18 December 2024

Our Ref: 2024/707984
File No: R/2024/4/B

Powerhouse Ultimo Revitalisation – 494 Harris Street, Ultimo – SSD-67588459 – Advice on Response to Submissions

FFL, 1% AEP Flood Level and PMF Flood Level along Harris St and Macarthur St

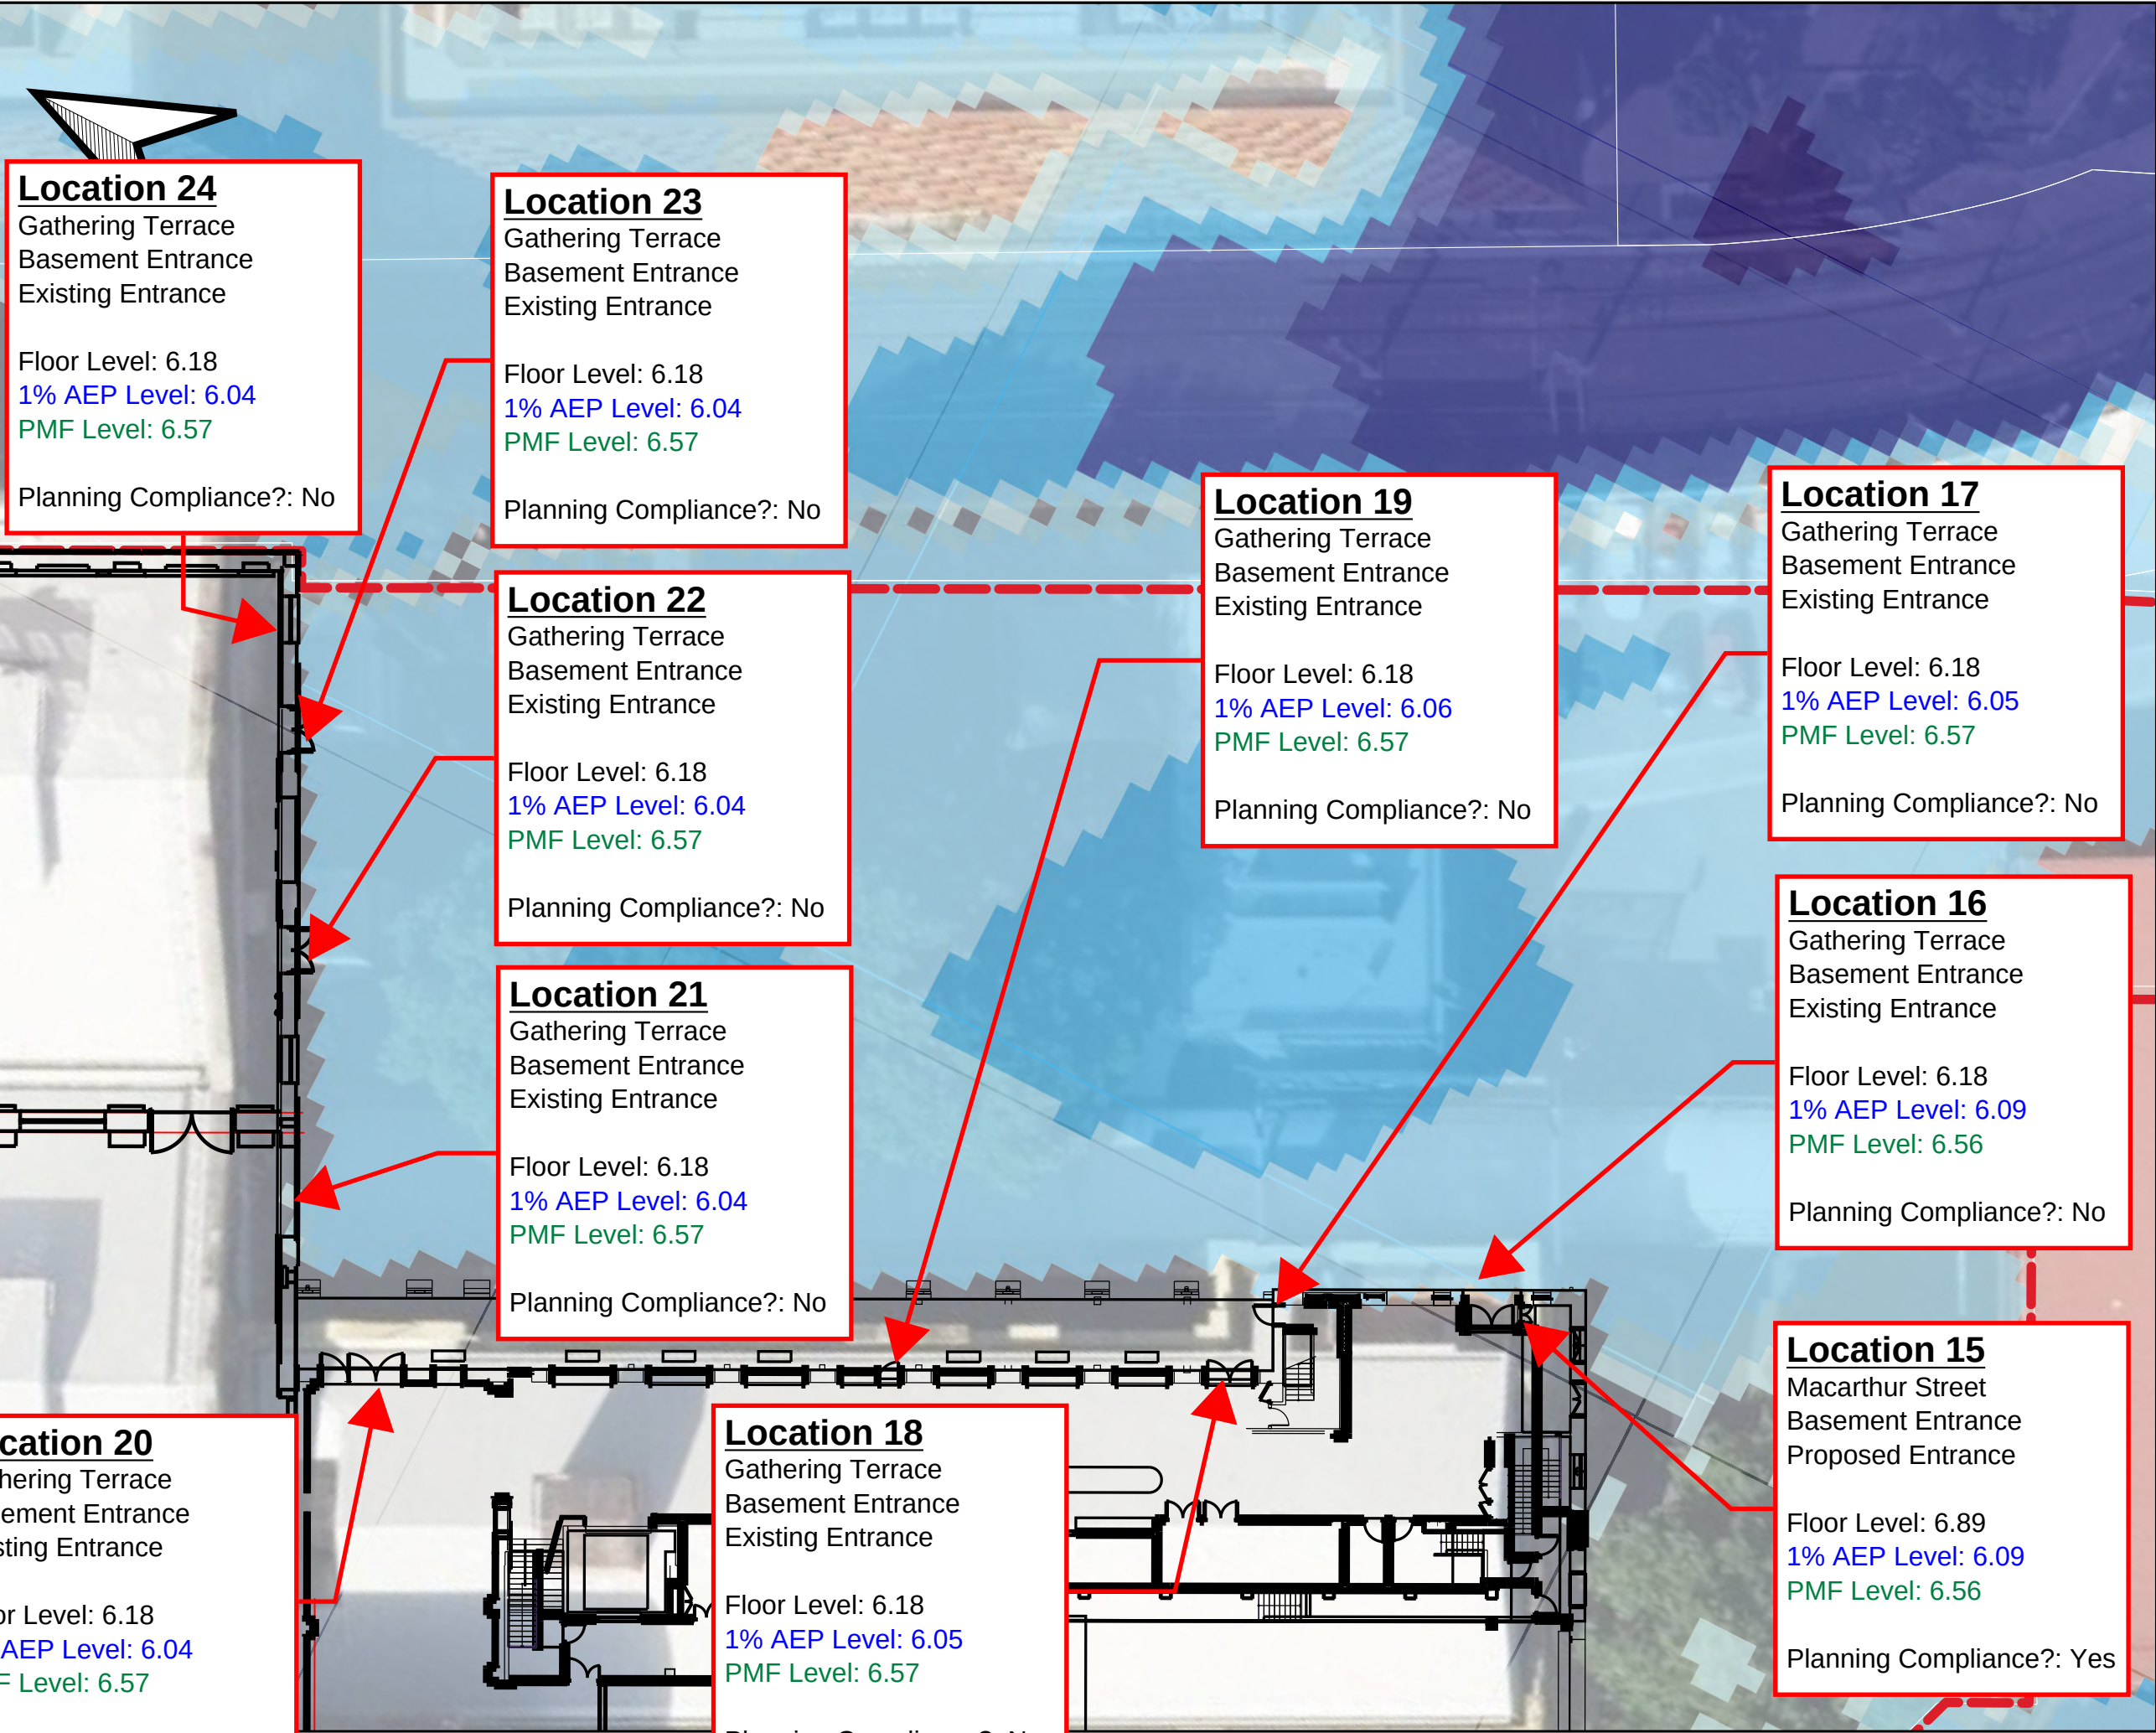
A stormwater and flooding response has been submitted by the Proponent that generally addresses the flooding issues raised by the City. The response notes that entrance 11a is not compliant, and that compliance can be achieved with an amended floor level that has not been captured in the architectural drawings.

The City recommends that the drawings be amended to ensure that Entrance 11a complies with the applicable flood planning level noted in Table 3 of the stormwater and flooding response.
